**Subject:** Cloud+  
**Page Label:** 1  
**Date:** 6/20/2018 3:50:23 PM  
**Author:** dsdrice  
**Color:** ■  
**File Name:** Drainage\_V1.pdf  
**Label:**

CD Civil Project No. 18002

PPR-18-024

PROJECT NO./CODE
Sheet Subset Number
Sheet Number GEC-1

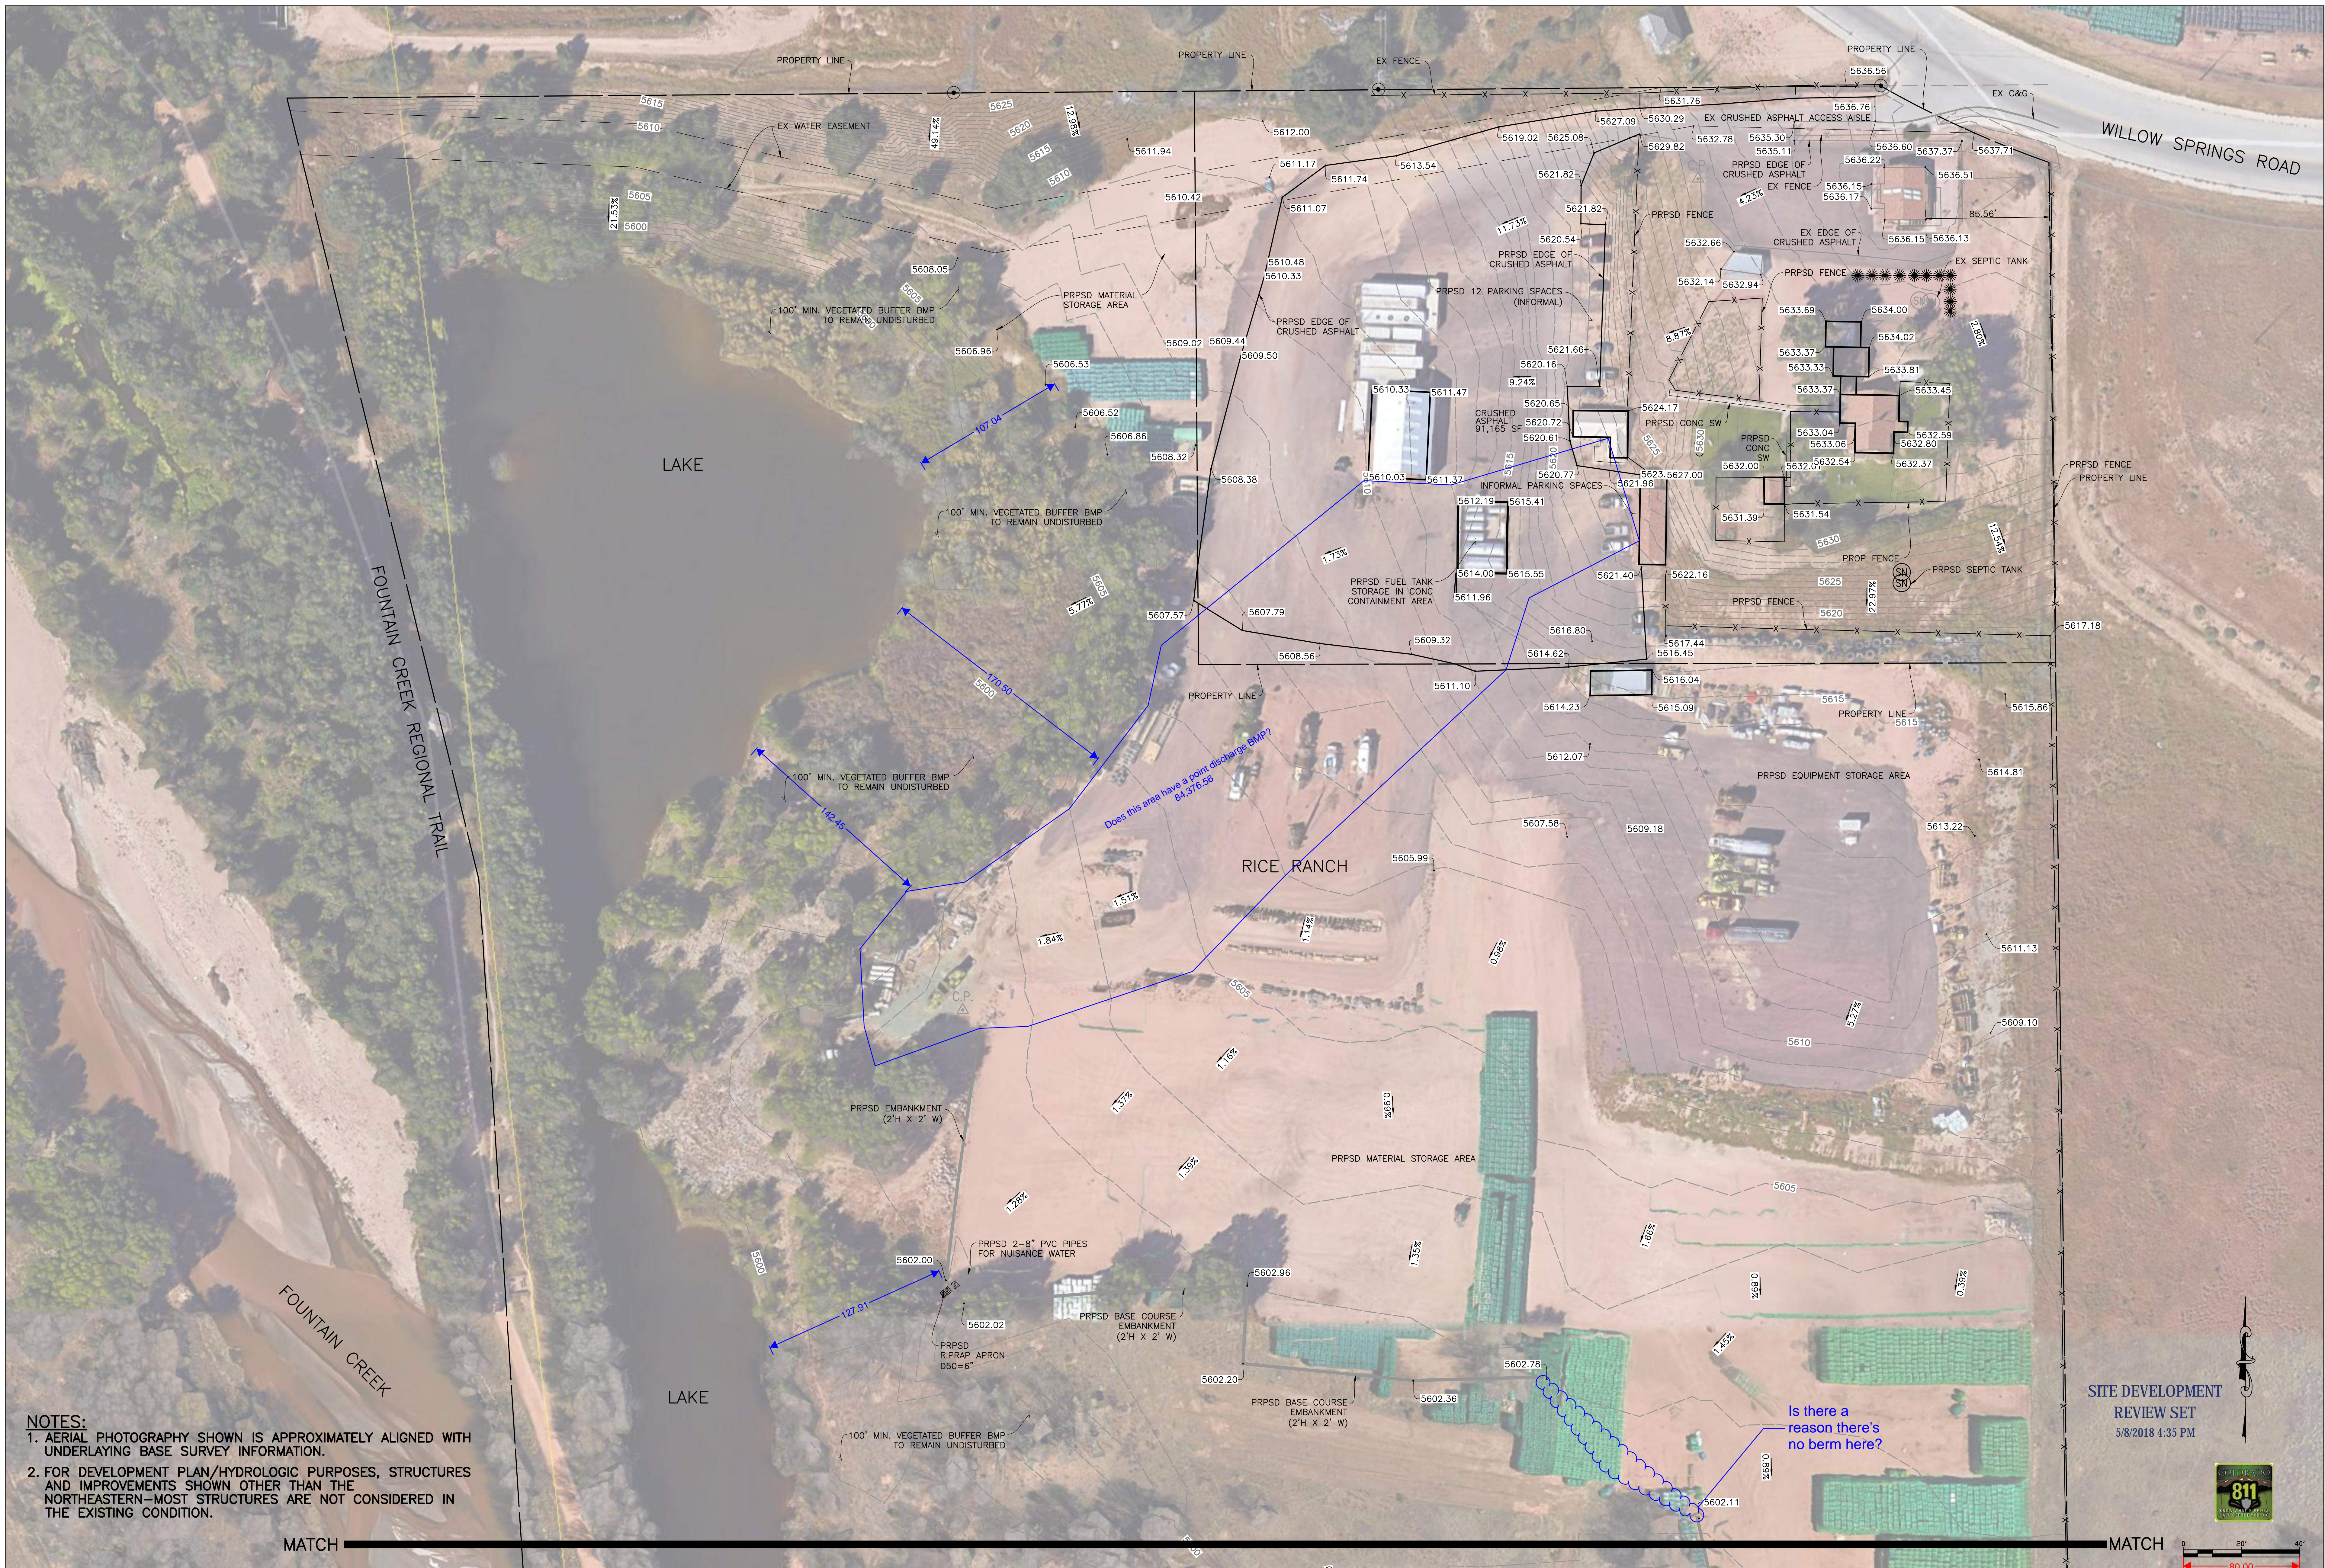
**Subject:** Area Measurement  
**Page Label:** 2  
**Date:** 6/20/2018 11:36:53 AM  
**Author:** dsdrice  
**Color:** ■  
**File Name:** GEC\_V1.pdf  
**Label:** Does this area have a point discharge BMP?

Is there a reason there's no berm here?

-----  
**Subject:** Text Box  
**Page Label:** 3  
**Date:** 6/19/2018 12:29:45 PM  
**Author:** dsdrice  
**Color:** ■  
**File Name:** GEC\_V1.pdf  
**Label:** Show and label limits of all water quality vegetative buffer strips to be maintained in accordance with the drainage report.
